CITY OF ALBUQUERQUE

October 5, 2022

Re: Improvements to AMAFCA Offices
2600 Prospect Ave. NE
Traffic Circulation Layout
Architect's Stamp XX-XX-XX (H16-D086)

Based upon the information provided in your submittal received 09-07-22, the above referenced plan cannot be approved for Building Permit until the following comments are addressed:

TRAFFIC CIRCULATION LAYOUT (TCL)

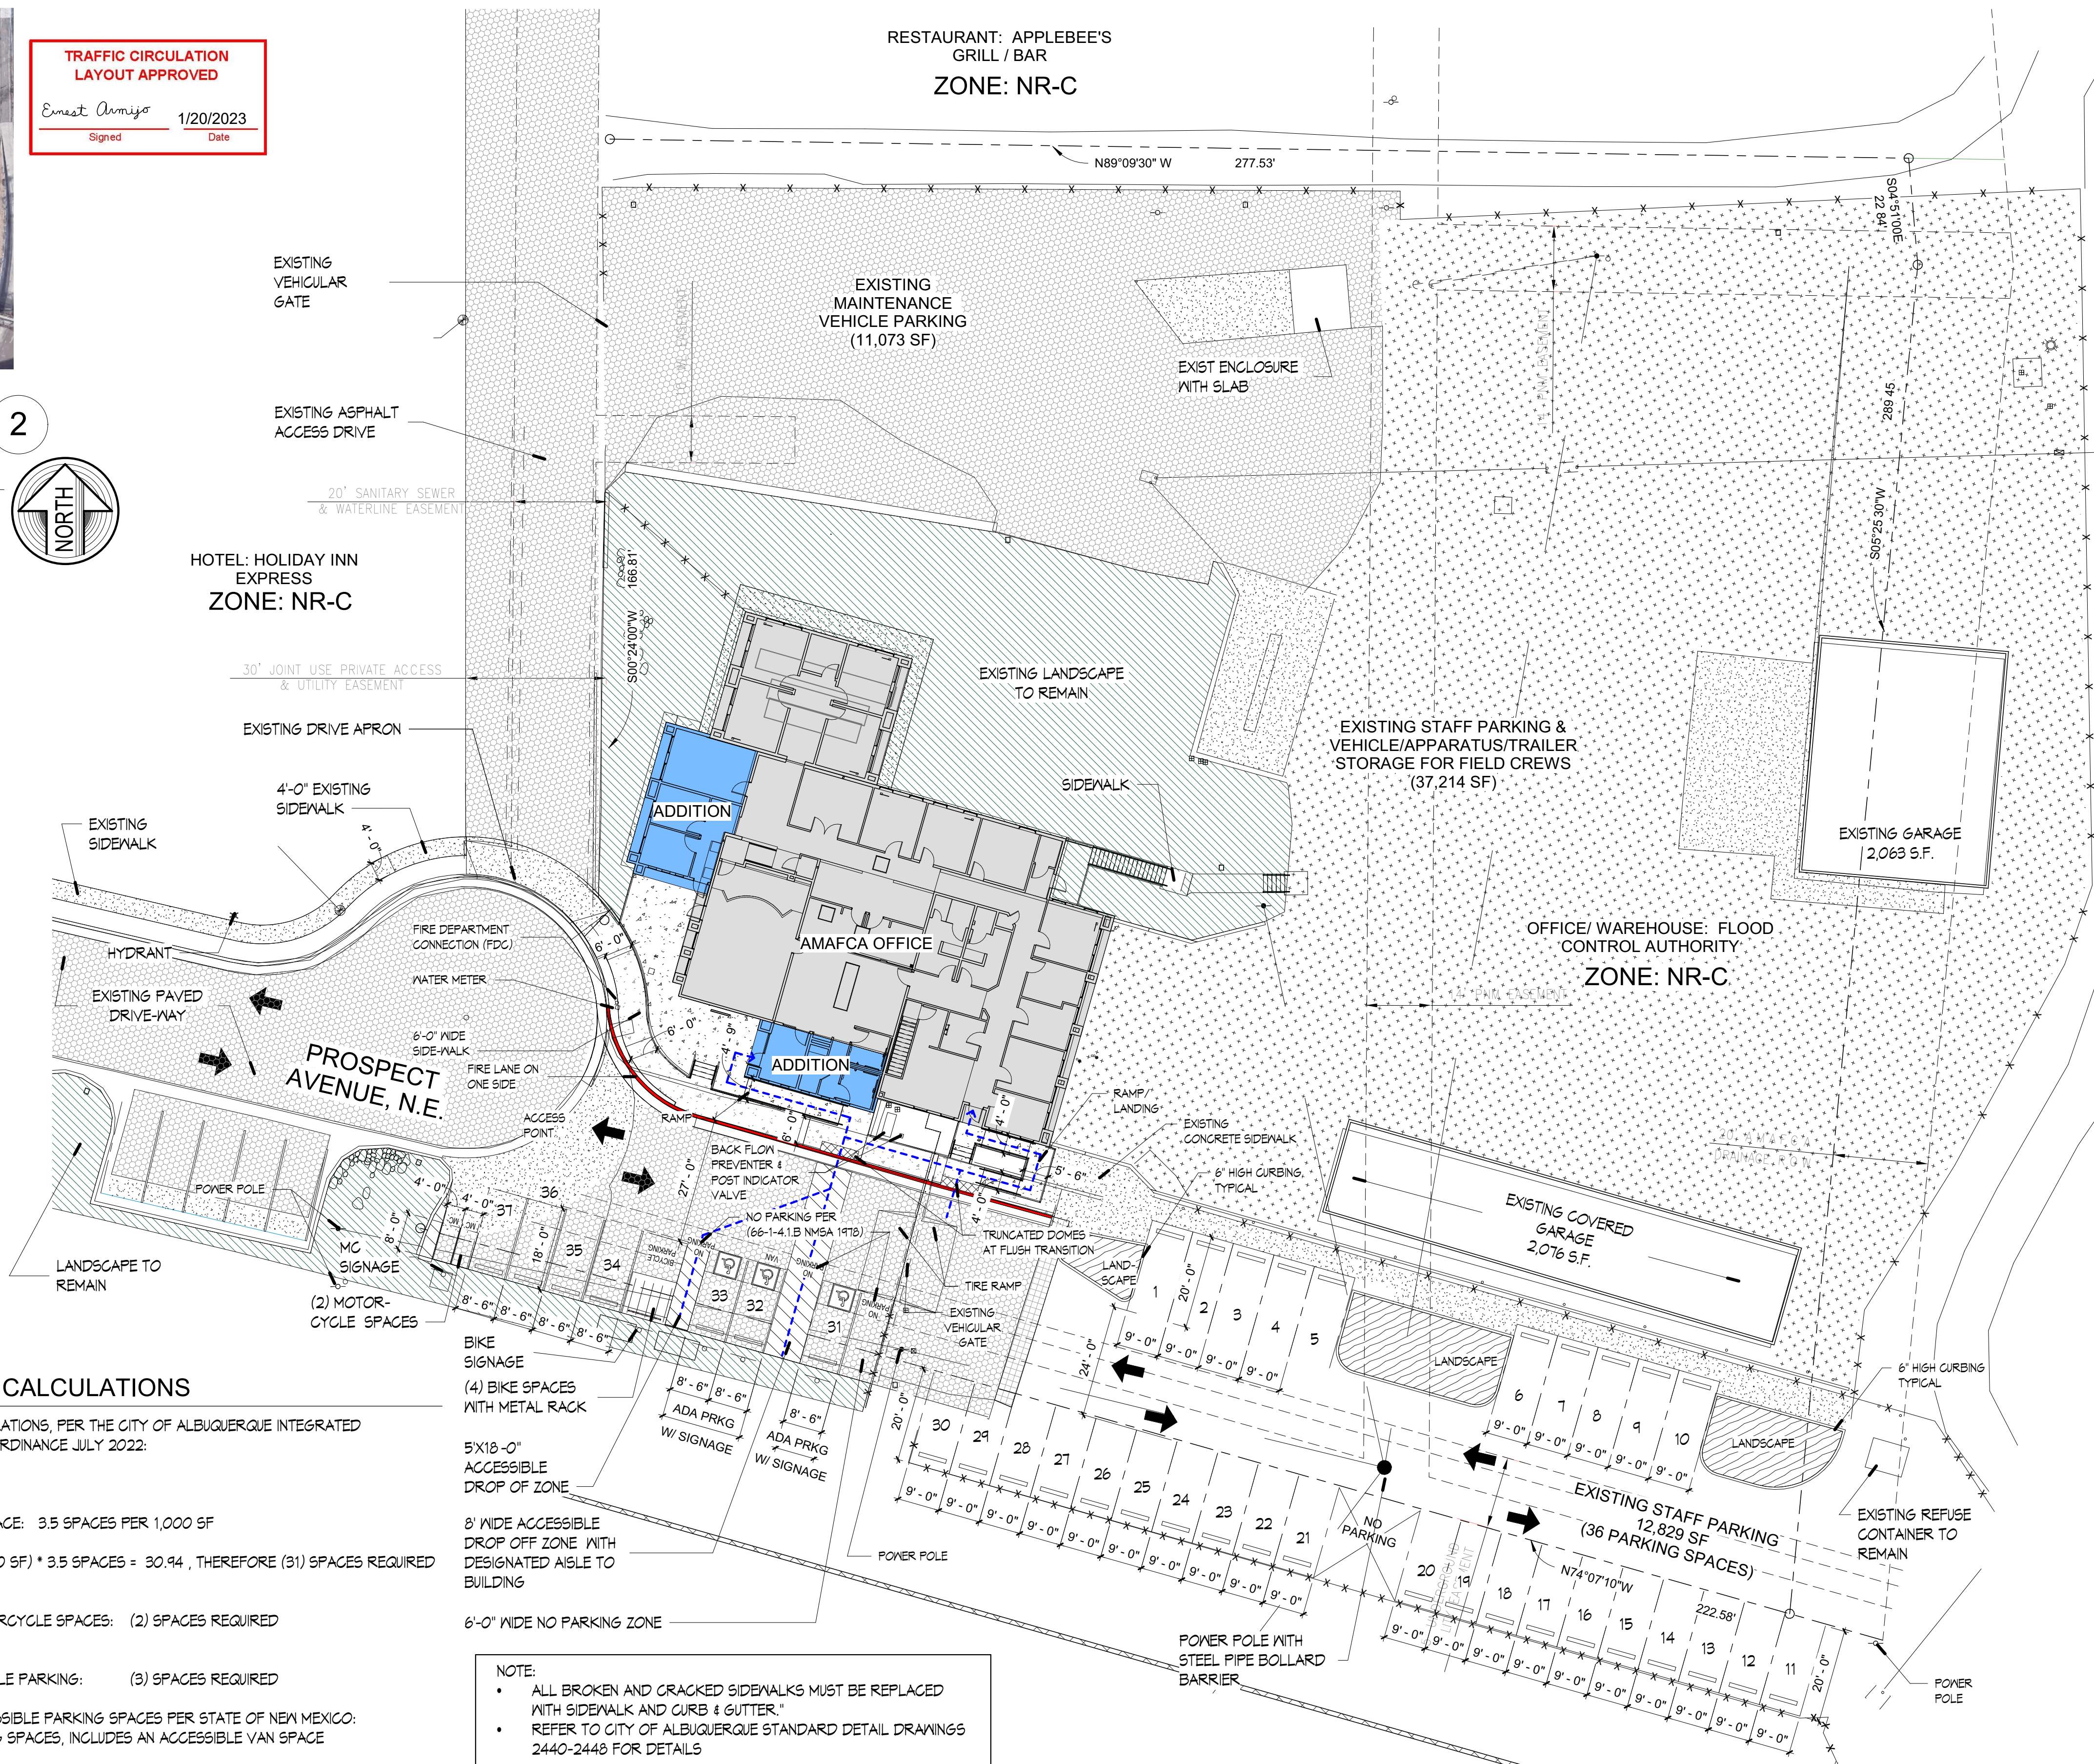
1. List the number of parking spaces required by the IDO as well as the proposed number of parking spaces including bicycle and motorcycle parking.
2. Please list the width and length for all existing and proposed parking spaces. Some dimensions are not shown.
3. The minimum parking stall dimensions are:

4. The ADA accessible parking sign must have the required language per 66-7-352.4C NMSA 1978 **"Violators Are Subject to a Fine and/or Towing."** Please call out detail and location of signs.
5. The ADA access aisles shall have the words **"NO PARKING"** in capital letters, each of which shall be at least one foot high and at least two inches wide, placed at the rear of the parking space so as to be close to where an adjacent vehicle's rear tire would be placed. (66-1-4.1.B NMSA 1978)
6. Please provide details for all the existing and proposed ADA ramps.
7. ADA curb ramps must be updated to current standards and have truncated domes installed.
8. Key note 17: please reference COA std dwg 2430 for the proposed sidewalk.
9. Motorcycle parking spaces shall be designated by its own conspicuously posted upright sign, either free-standing or wall mounted per the zoning code.

10. The pavement marking "MC" should be shown in the opposite direction for Motorcycles entering the parking space.
11. All bicycle racks shall be designed according to the following guidelines:

12. Bicycle racks shall be sturdy and anchored to a concrete pad.
13. A 1-foot clear zone around the bicycle parking stall shall be provided.
14. Bicycle parking spaces shall be at least 6 feet long and 2 feet wide.

15. Per the IDO, a 6 ft. wide ADA accessible pedestrian pathway is required from the public sidewalk to the building entrances. Please clearly show this pathway and provide details.

16. Refuse vehicle maneuvering shall be contained on-site. The refuse vehicle shall not back into the public right of way.; provide a copy of refuse approval.

17. Provide a copy of Fire Marshal approval.
18. Please specify the City Standard Drawing Number when applicable.
19. Add a note stating "All broken or cracked sidewalk must be replaced with sidewalk and curb & gutter." A build note must be provided referring to the appropriate City Standard drawing.
